**COLORADO SPRINGS
MY PLACE HOTEL**

NEAR STRUTHERS ROAD &
GLENEAGLE GATE VIEW

Landscape plan
 Project name

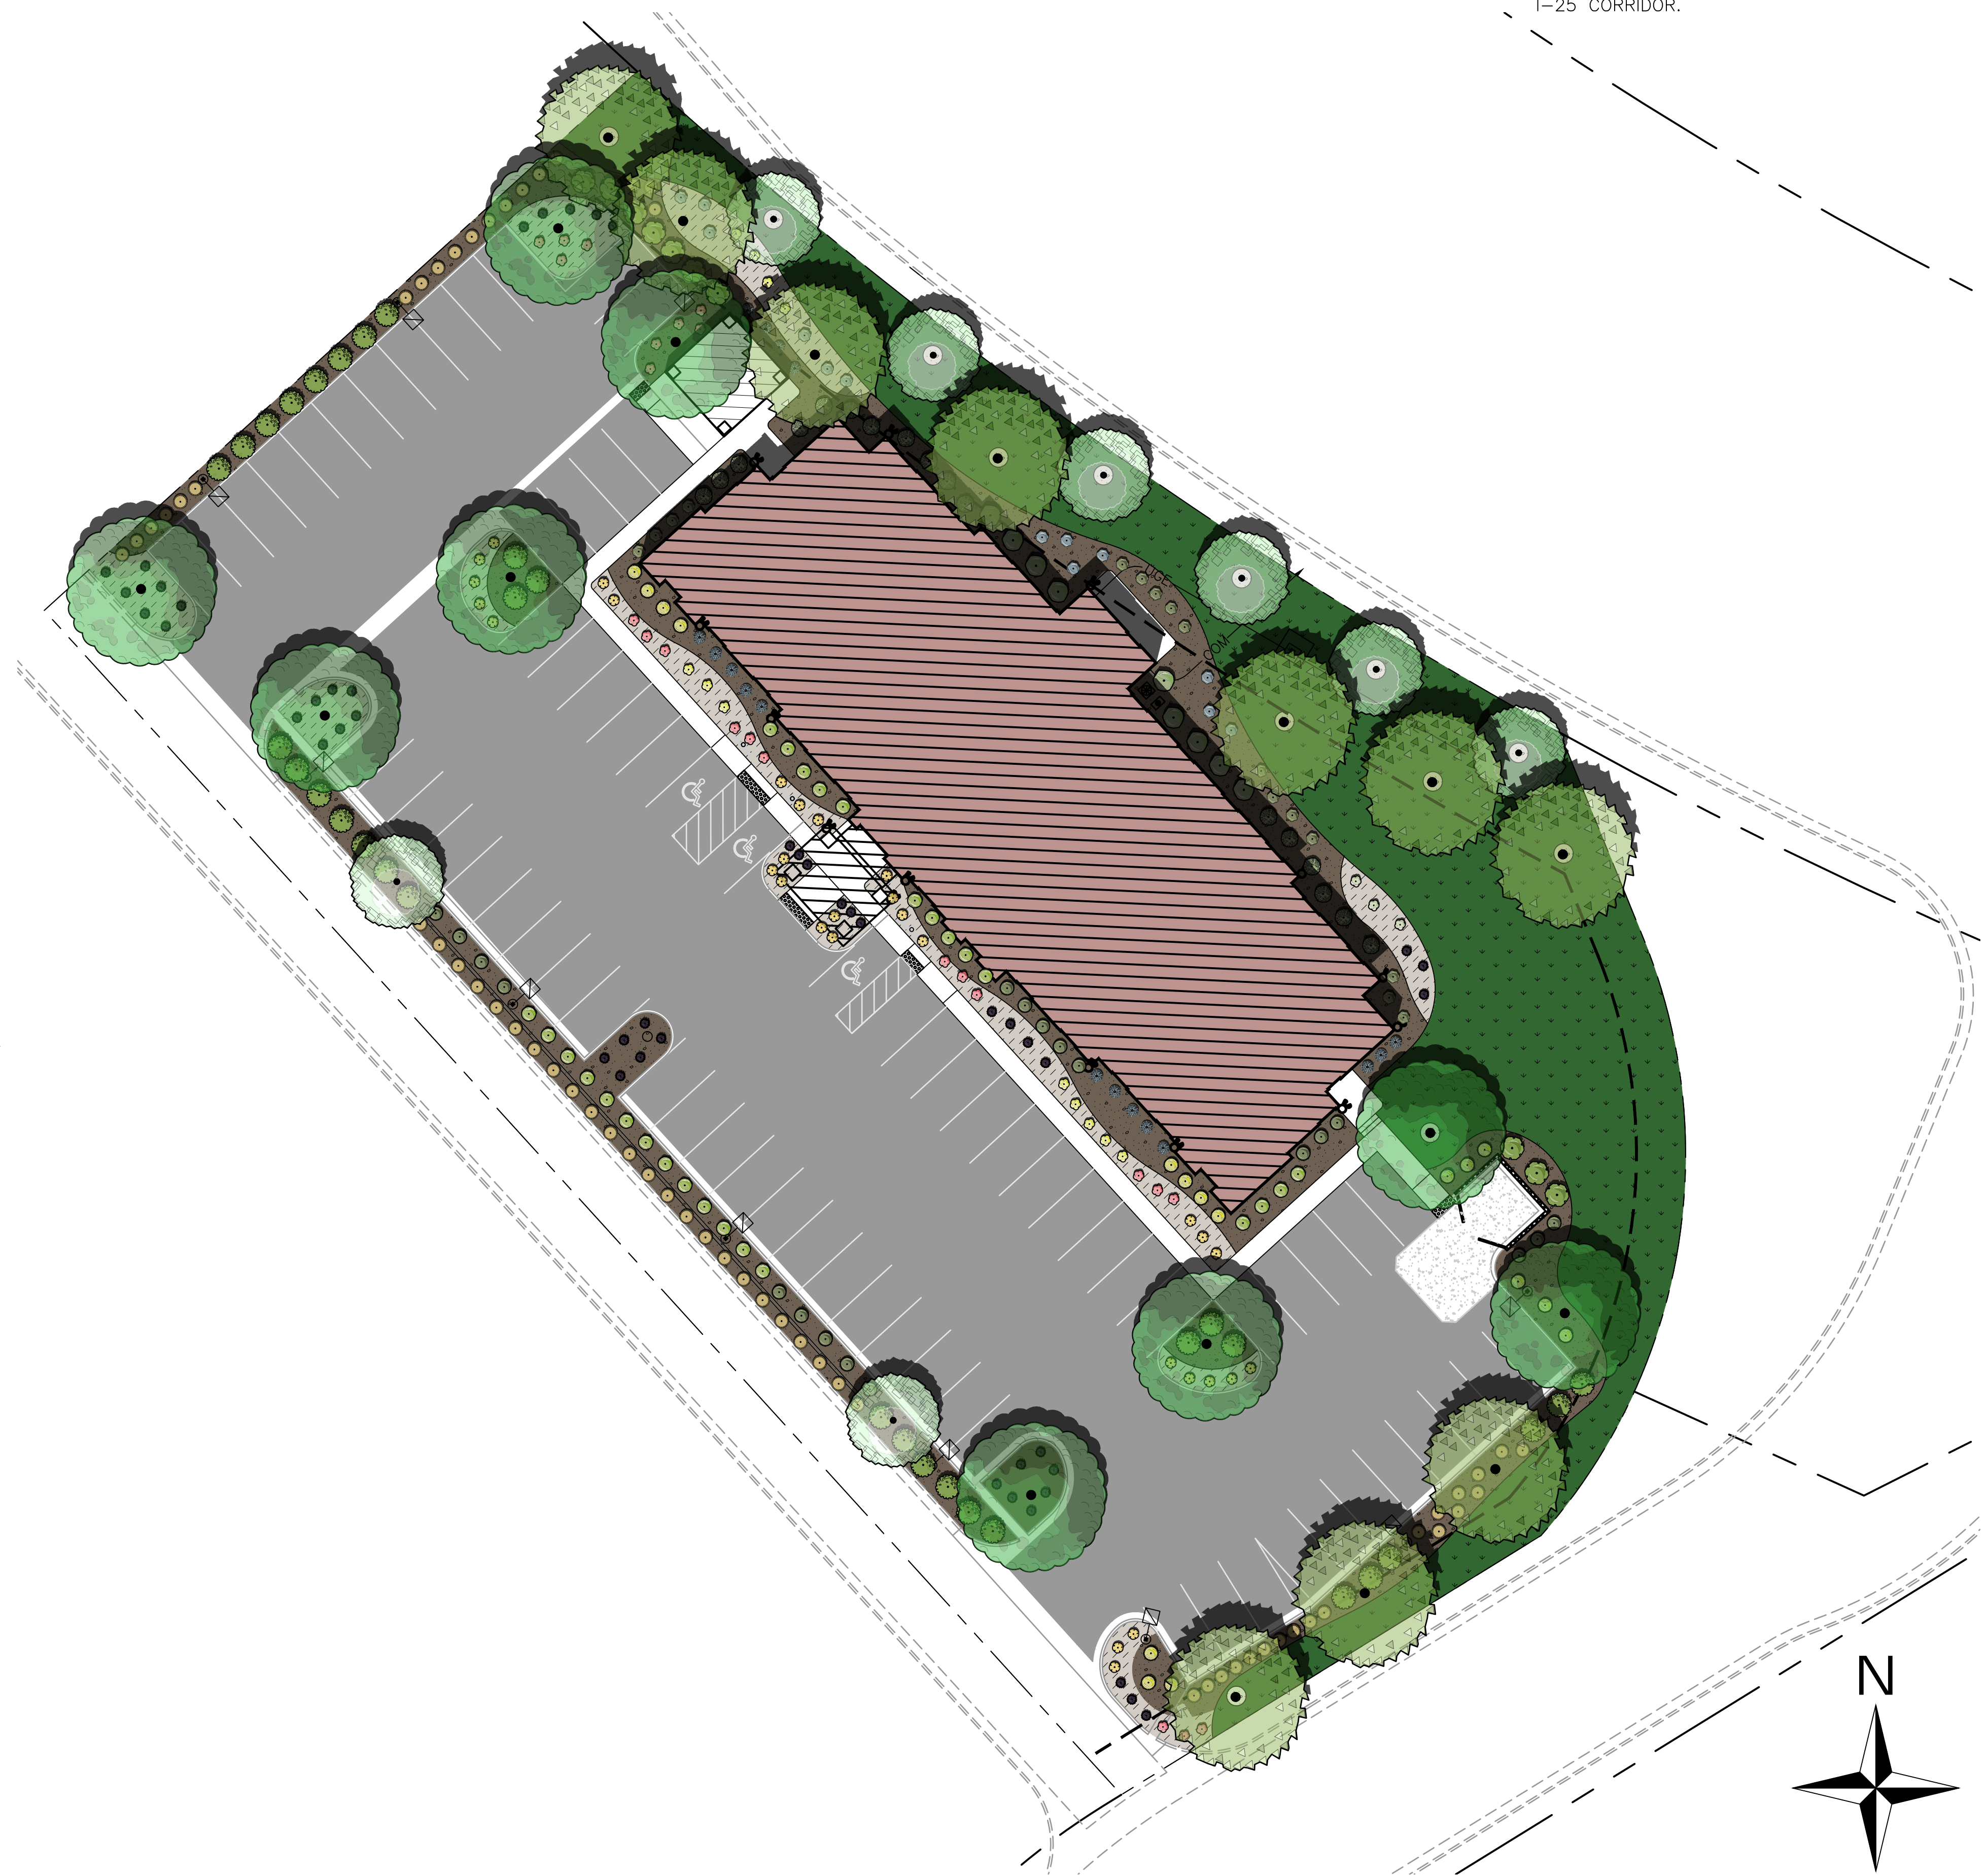
Identify the category: Parking, Roadway (private and public), Internal, and zone district boundary (if applicable). The amount required for each category and the amount planted. Justify any shortages as an alternative landscape plan.

Please cross check the check list of items from the landscape plan list and place on the landscape plan. The list was emailed to you on 8-30-17

Identify property lines, landscape setbacks. See landscape plan checklist and add missing items
